CITY OF ALBUQUERQUE

Re: Duggers Towing, Grading and Drainage Plan
Engineer's Stamp Date 04-02-2013 (D-18/D034)

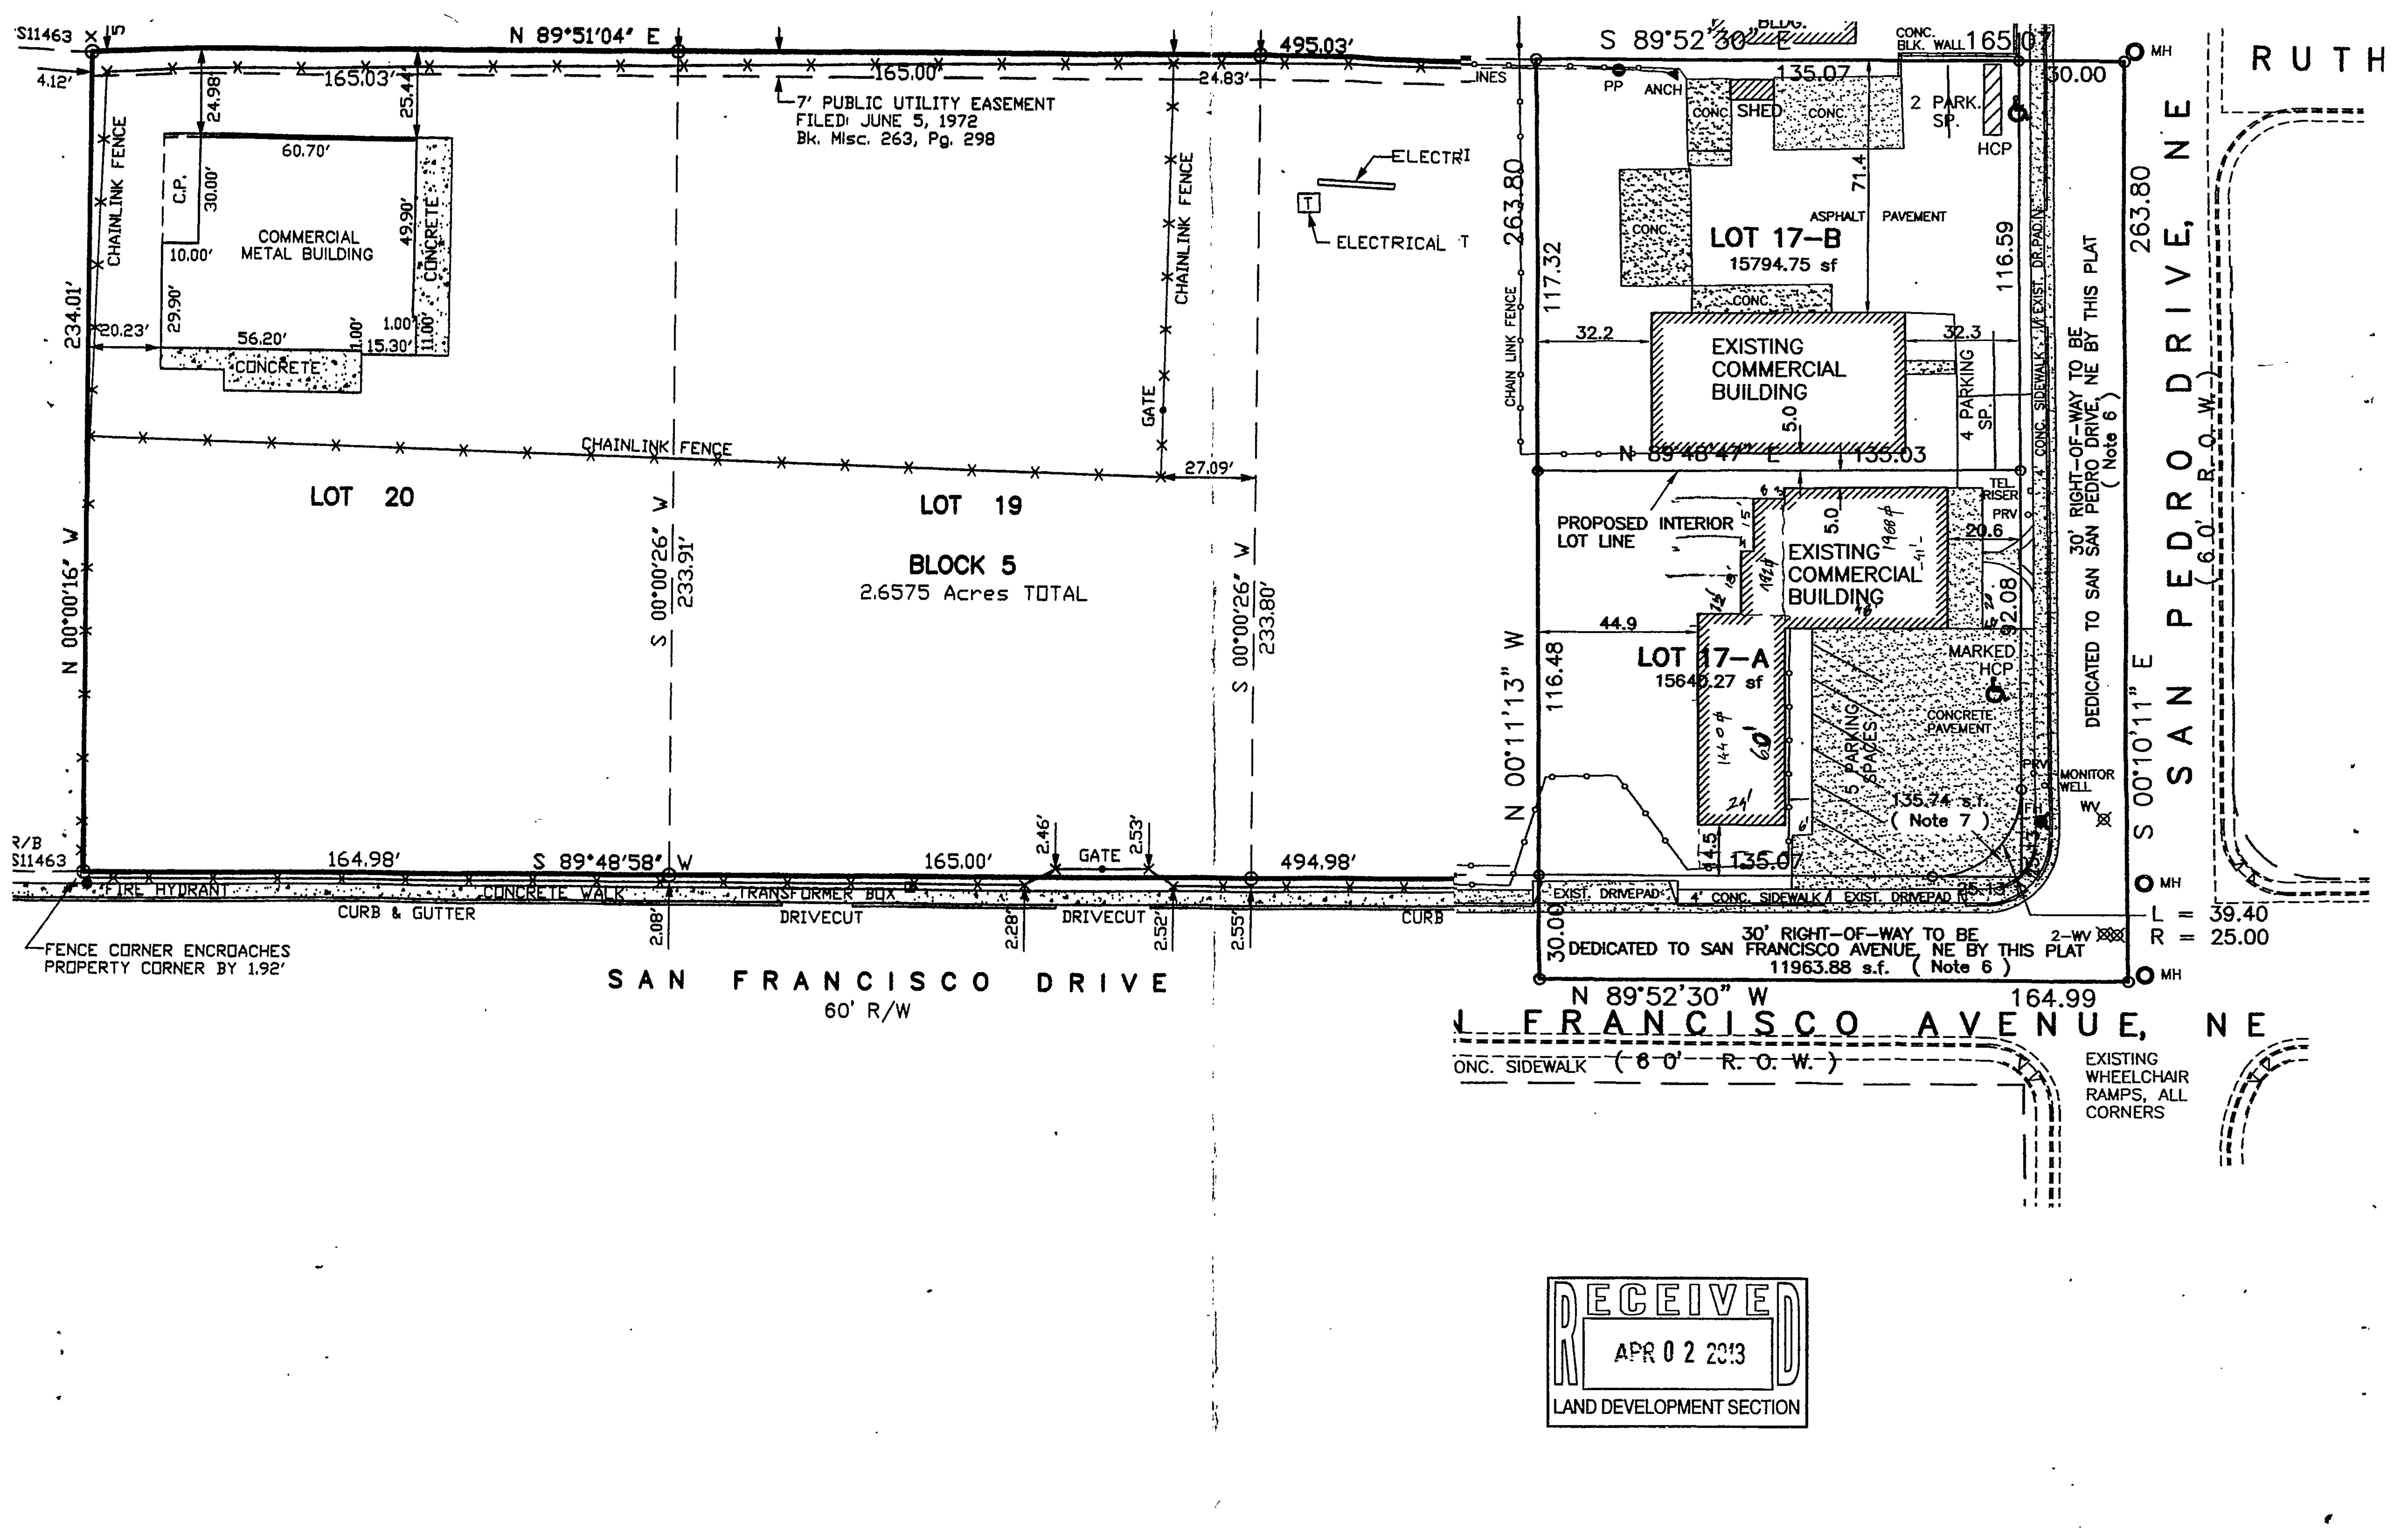
- Please quantify all off-site flows being received and show how these flows will leave the site.
- Provide additional spot elevations of the site interior as well as extend contours and show additional spots to the west of the property.
- Clarify the property boundaries; show all sidewalk, curb and gutter elevations and flowlines along San Francisco Drive.
- The proposed retention pond will be required to hold the full 10-day volume of developed and concentrated flows from the site; Hydrology suggests the implementation of a detention pond with ultimate discharge through a sidewalk culvert onto San Francisco Drive.
- How will the channelized flows be directed around the bends into the proposed pond without topping over?
- Will there be any parking requirements for the proposed building?
- Provide a benchmark designation on the grading plan.
